Your Ref: Inet 000009919
Our Ref: EP/123/10/
Please ask for:
Mr J Smith

14th December 2010

Outline Application with all matters reserved for a proposed sustainable dwelling with parking area and store building.

Crinnis House Seafield Road East Preston

C		
B		
A		
Client	C. DENCH ESQ.	
Address	Crinnis House : SEAFIELD ROAD EAST PRESTON	
Drawing	PLANS	No. 2810:2
Scale	1:100 1:500 1:1250	Drawn <i>B</i> Date <i>Nov '10</i>

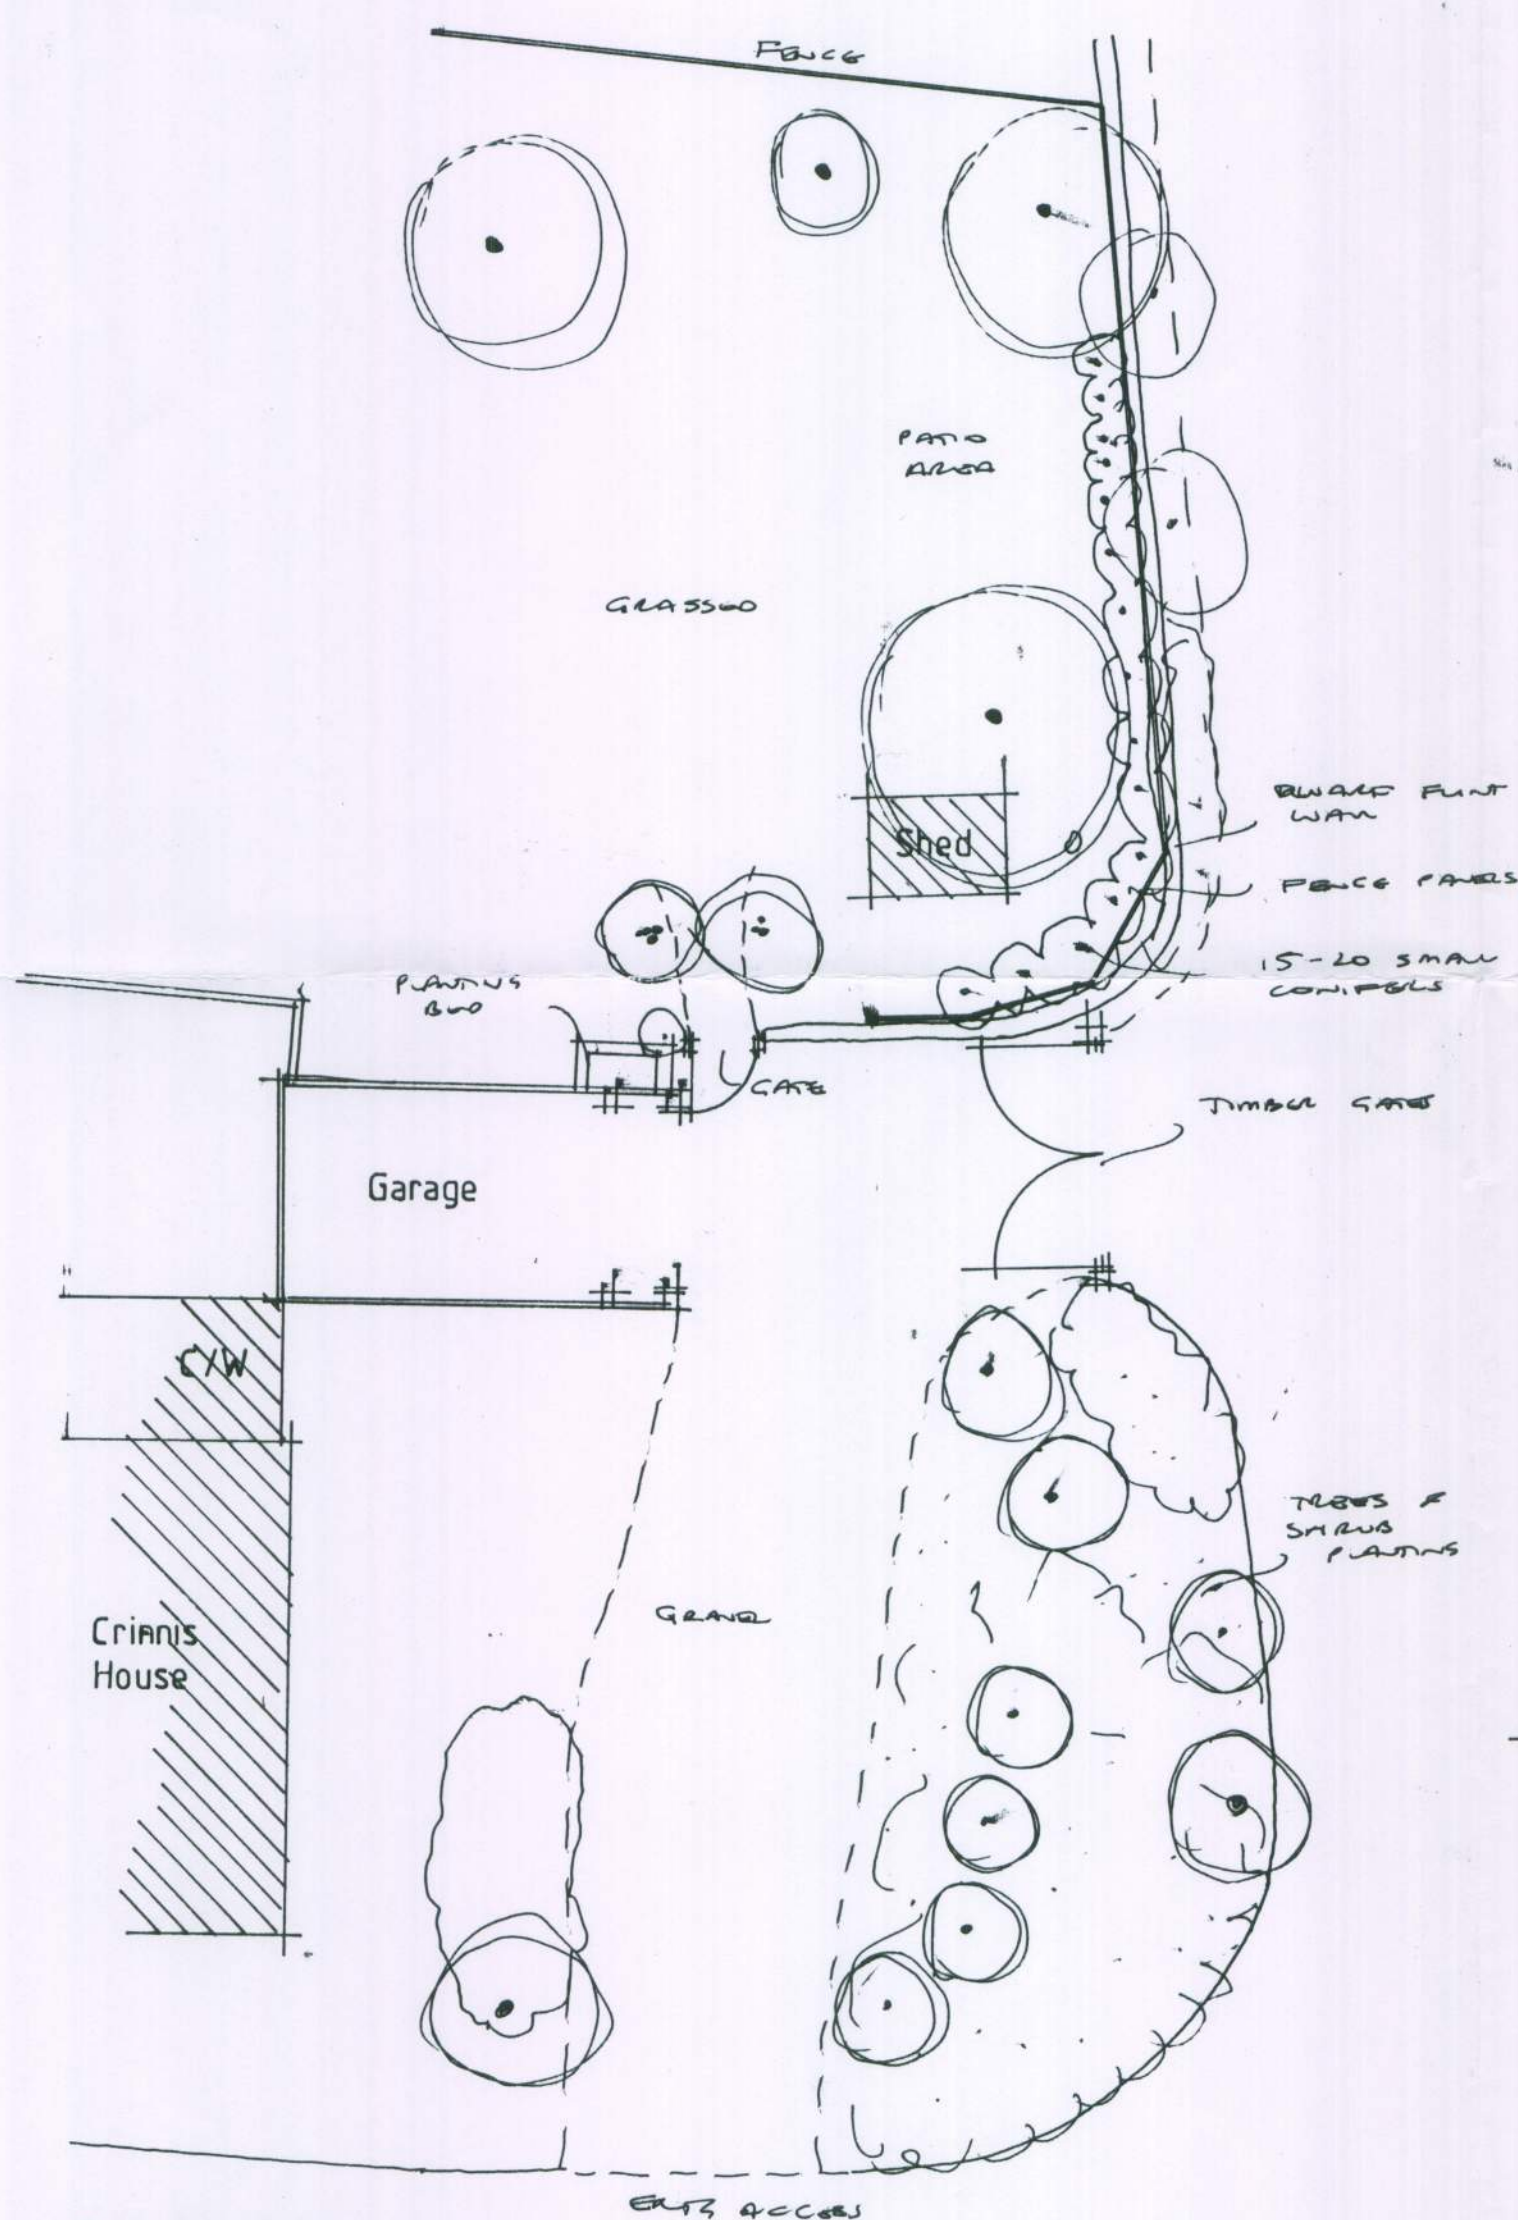
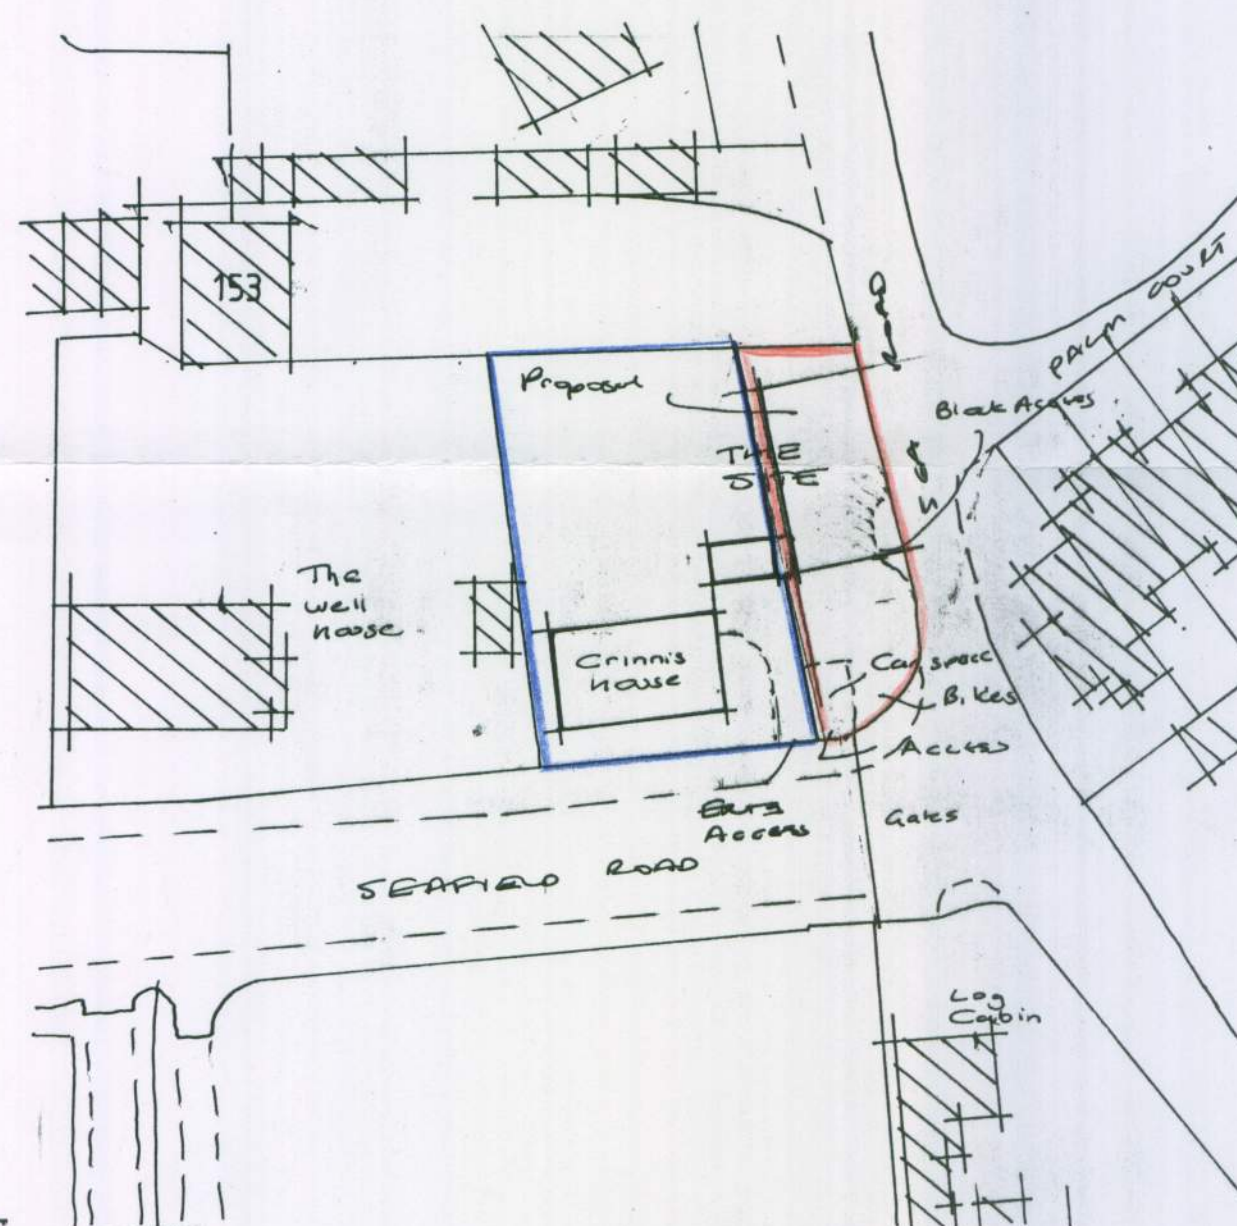
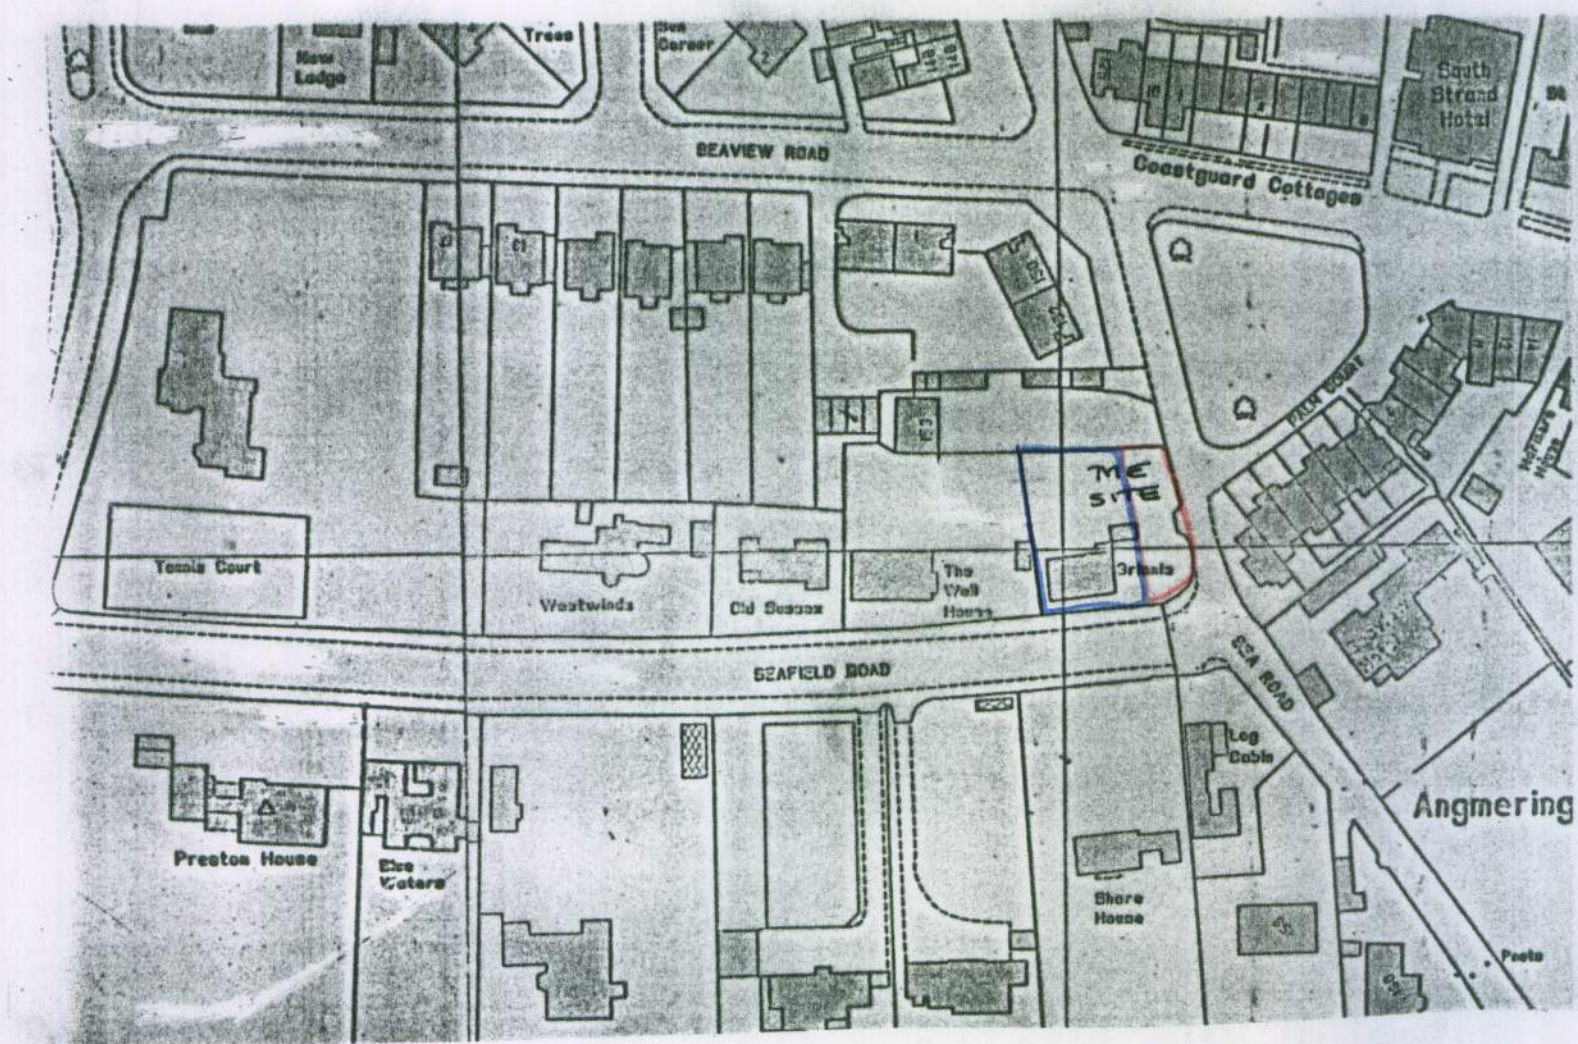
*I am happy to support this application providing that the issue of privacy is dealt with in relation to the 1st floor window nearest to our property, ie frosted or obscure glass.
The applicant and I have discussed this and he is willing to build this in to his design.*
